Hothersall Parish Council

6th July 2018

Re planning application 3/2018/0467 The Woodlands, Hothersall Lane

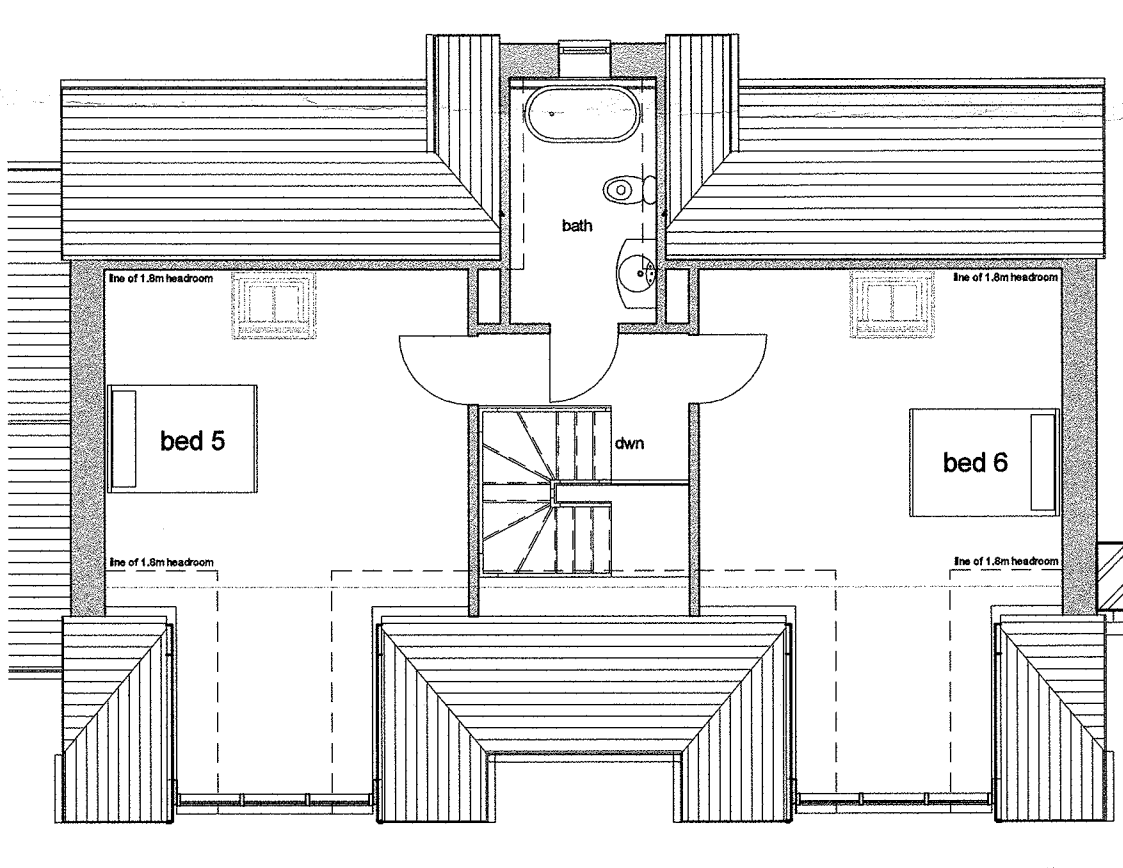
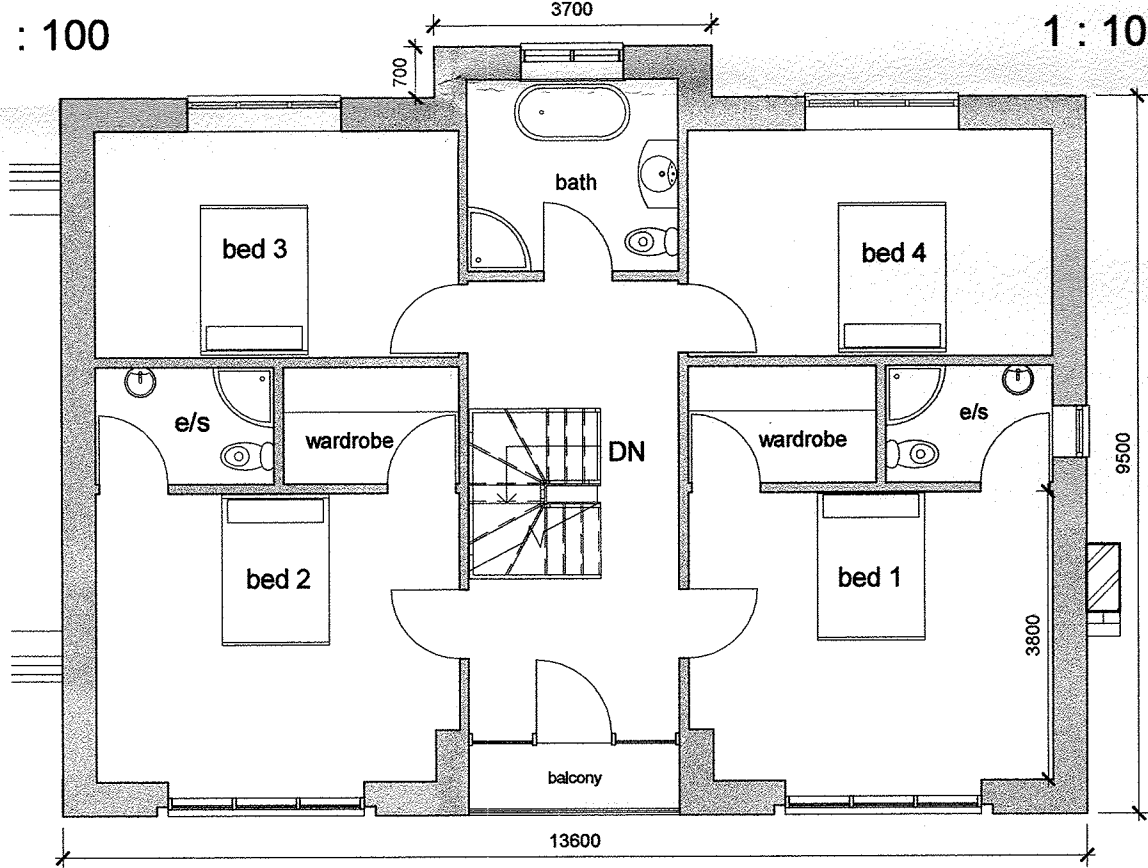
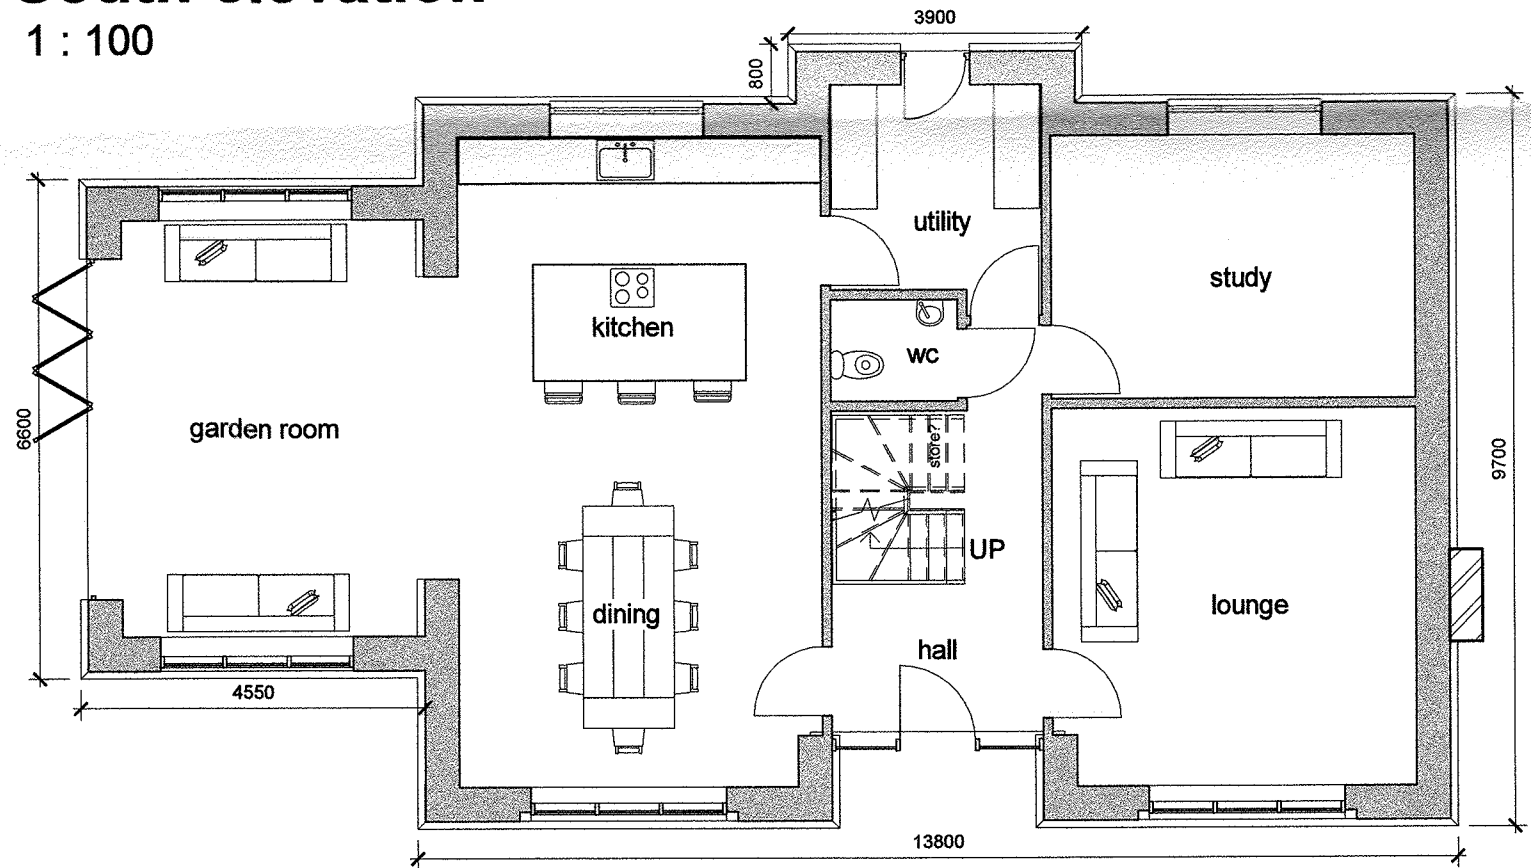
The details of the proposed new property are extremely sketchy at this stage and would need to be appropriate to the environment. Concerns have been expressed that the initial description states a two-storey building, when the design is obviously three-storey.

PROPOSED SITE PLAN

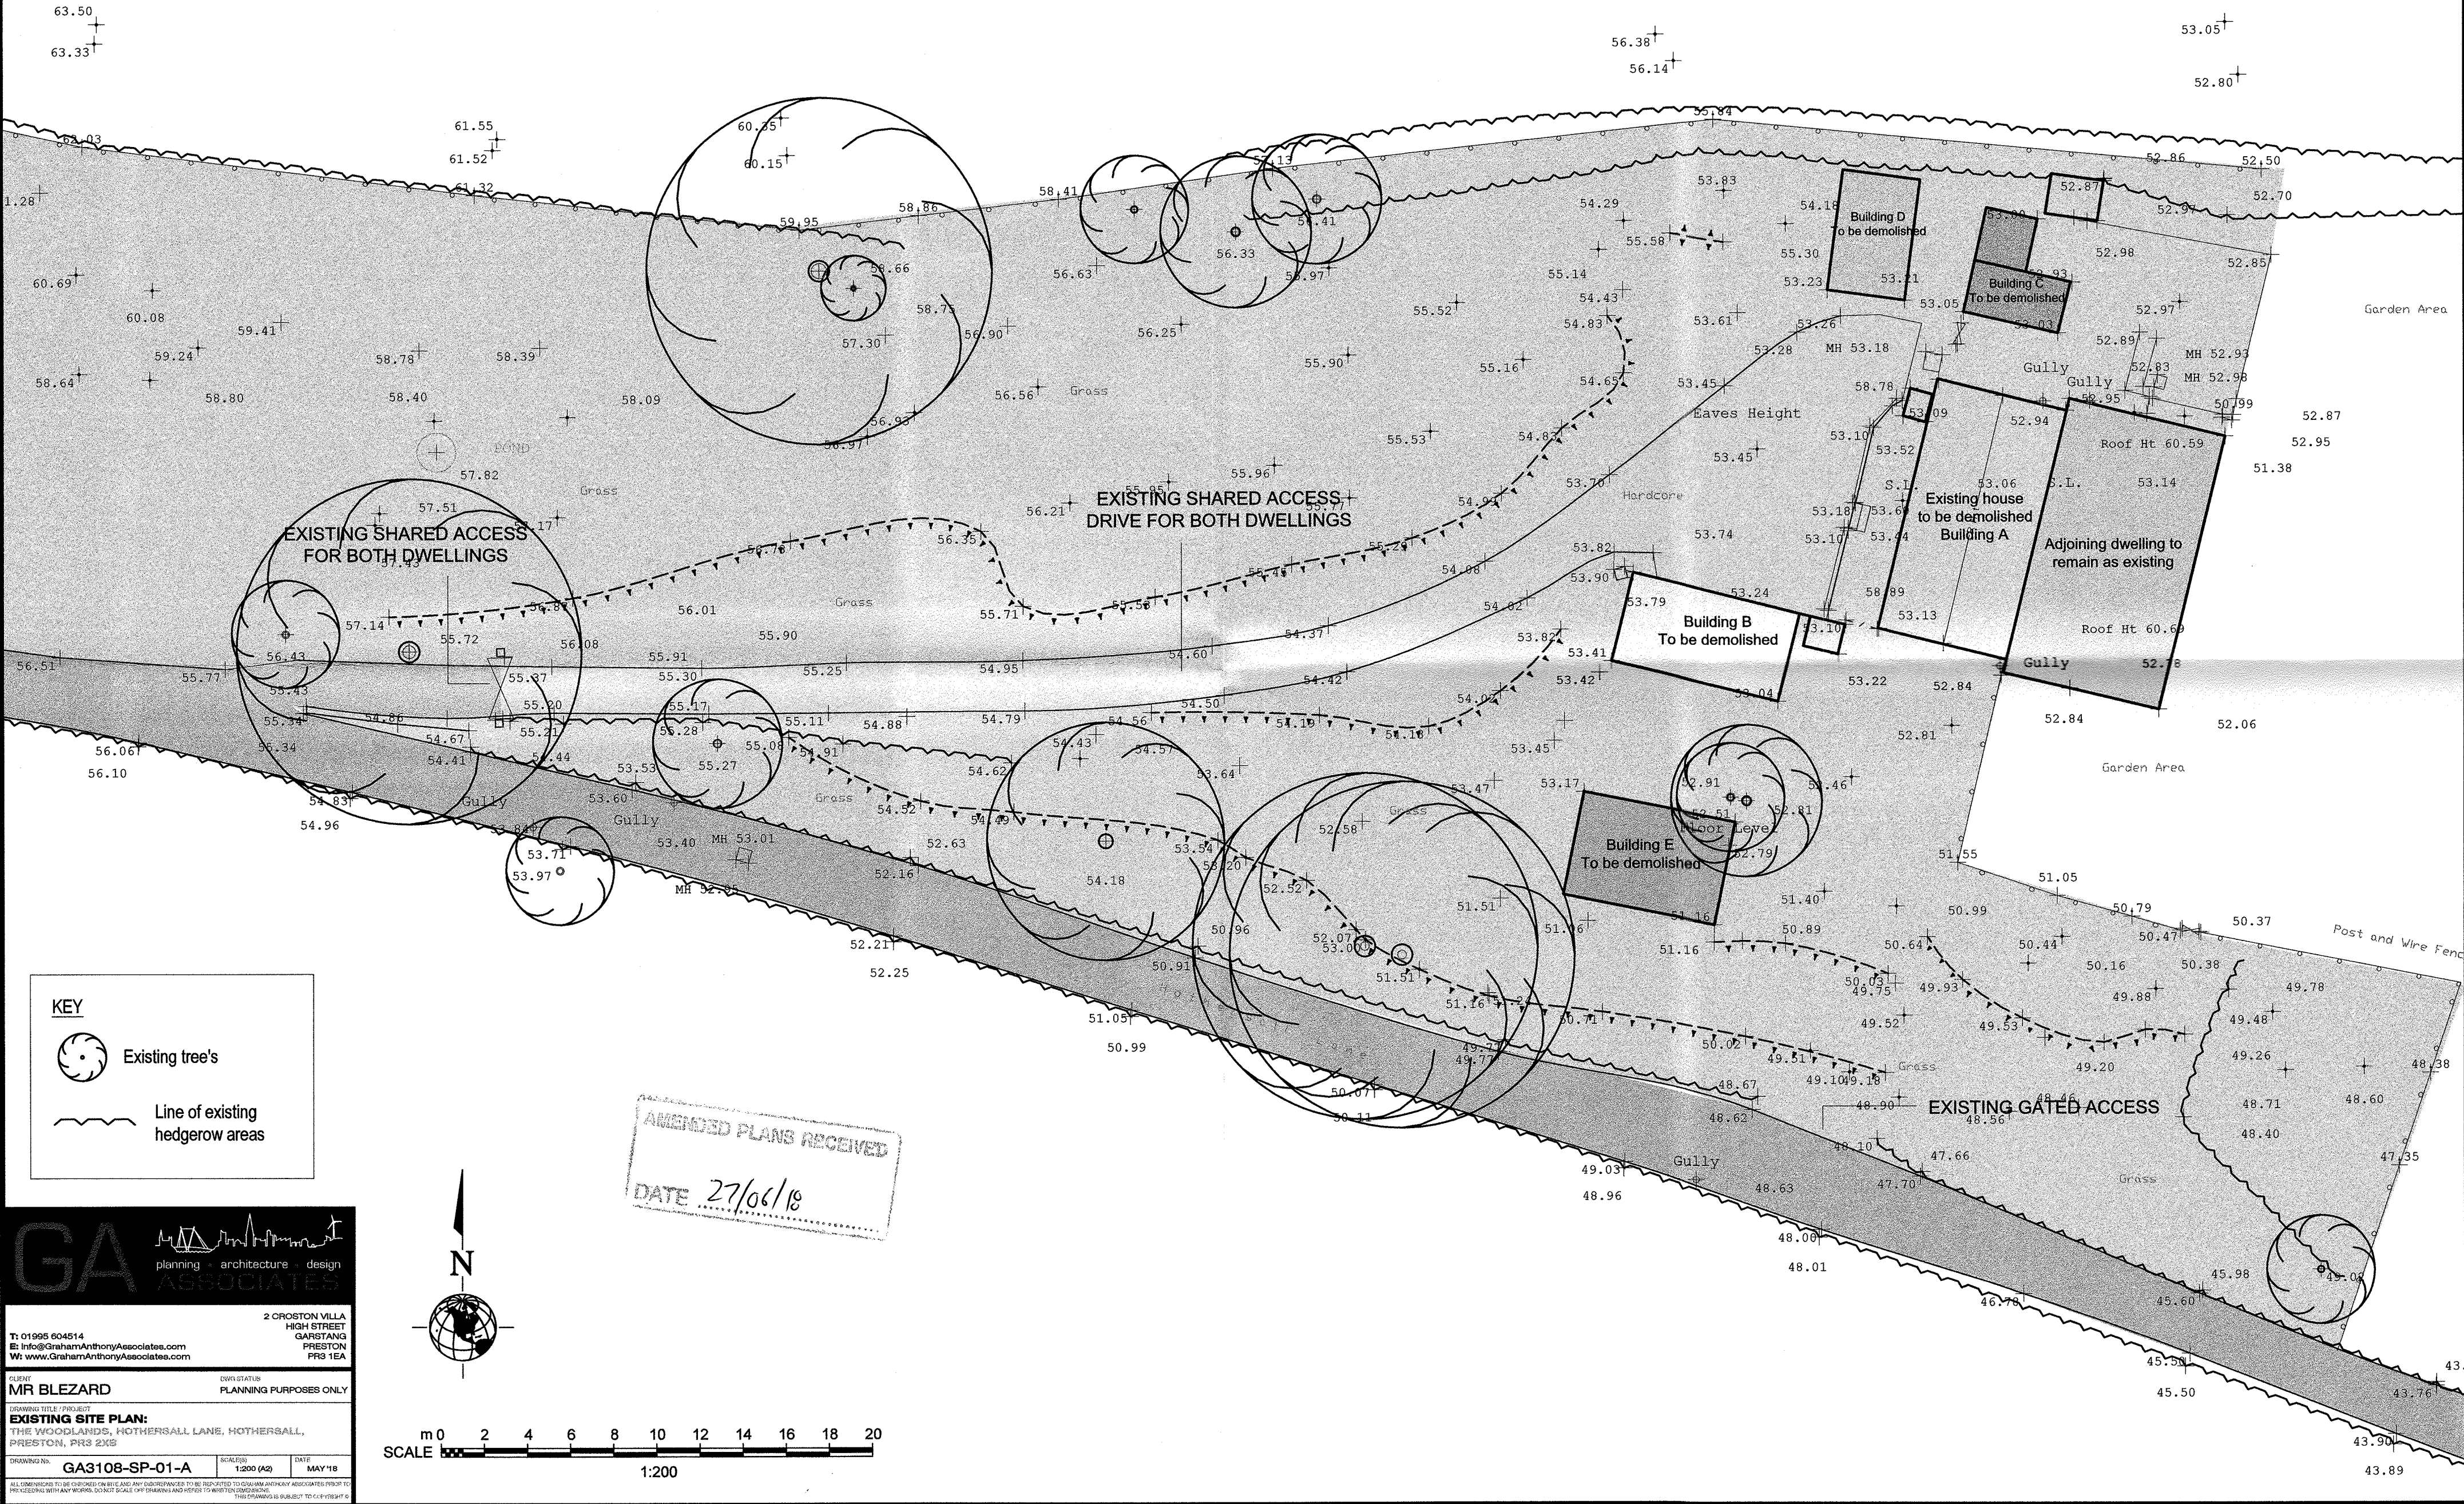
The problem of access remains. Understandably, the new property hopes to have it's own entrance, but this leaves a difficulty in providing access for the already developed property to the south. The very steep drive proposed seems difficult and there would need to be space provided off the narrow lane below to prevent obstruction. This would need to be arranged with the owners of the southerly property.
